Subject: RE: Y/9818/RES and Y/97/18/DOC

Laura Gibbons, MEng, GMICE
Engineer (Drainage & Coastal)

Job Title			
LAND SOUTH OF BURNDELL ROAD, YAPTON			
Drawing Title			
PRELIMINARY ENGINEERING LAYOUT			
Client			
BOVIS HOMES			
Scale	Date	Designed	SG
1:500 @A1	NOV 18		
Drawn	Checked	Approved	RS
SOM	LH		
Job No	Drawing No	Rev	
18-070	18-070/103	K

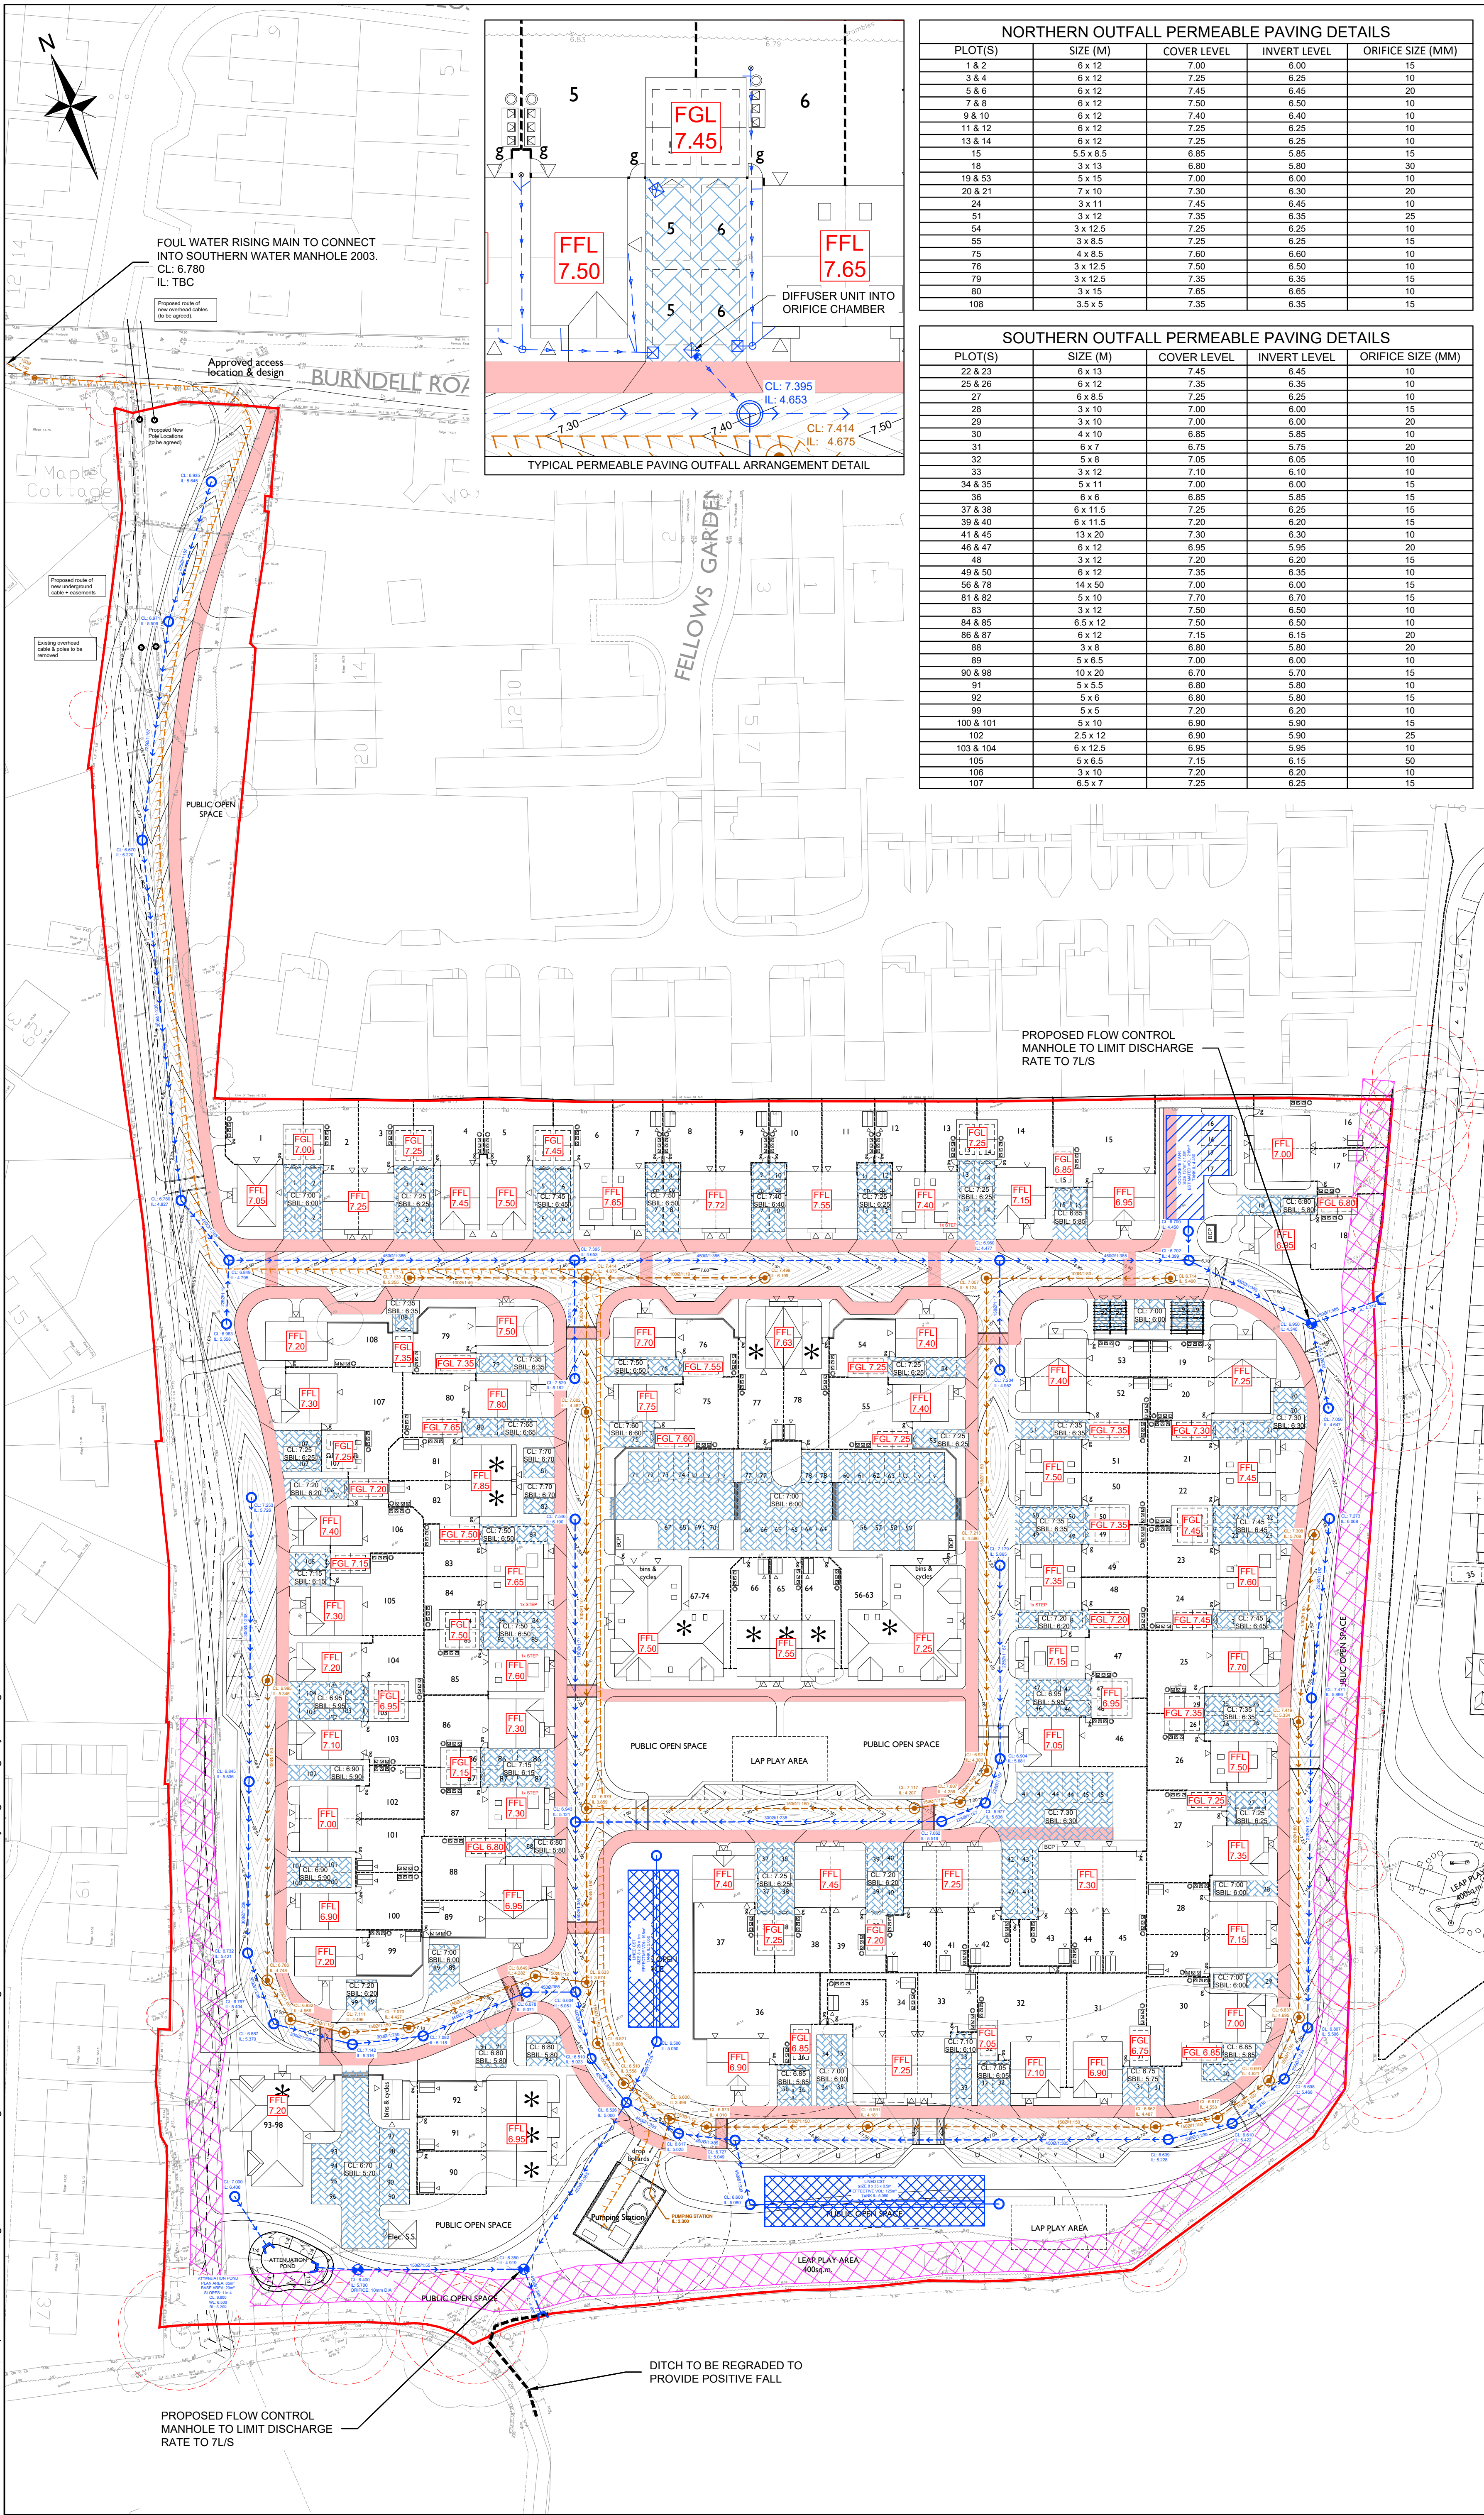
2. The flotation calculations for tank 3 assume that wet sand is being used as ballast. Yet stone is specified within the drawings. We have requested clarification from SDS and are awaiting a response however see item 3 below. *I will await these details. Tank 3 has been replaced by a concrete tank. See below.*

3. The constructability, design life, and maintenance of the arrangement proposed for tank 3 are a significant concern. Please re-consider providing counterbalance outside of the impermeable membrane (then you're also displacing less groundwater) and above the tank. We are looking at an alternative tank design for this tank and will forward details as soon as there are available. *I will await these details. We have changed this tank to a concrete tank by Carlow. Please find attached associated details from Carlow and our plan updated to suit.*

4. There are discrepancies between cover levels and invert levels of tanks in flotation calculations and on drawings. Updated drawings/calcs from SDS will be sent over shortly *I will await these details. Updated SDS details provided.*

6. Please provide a schedule of permeable paving subbase depths and orifice diameters. Schedule has been added to drawing. *okay. Noted*
7. Please provide finish and formation levels of permeable paving on plan. Finish and formation levels have been added to drawing and are also shown in the schedule. *Please ensure 150mm freeboard between cl of permeable paving and FFL, and 20mm between cl of permeable paving and FGL. The permeable paving design has a 300mm freeboard allowance in the design below the surface level to allow for block, bedding and tarmac.*

12. *Can you look at providing some upstream connections to the two southern tanks, to make them more online rather than offline. Offline tanks should be avoided where possible. I acknowledge that the northern most tank may have to stay offline. The main road sewer system is to be offered for adoption to Southern Water and they will not accept online tanks, only offline, privately maintained tanks.*
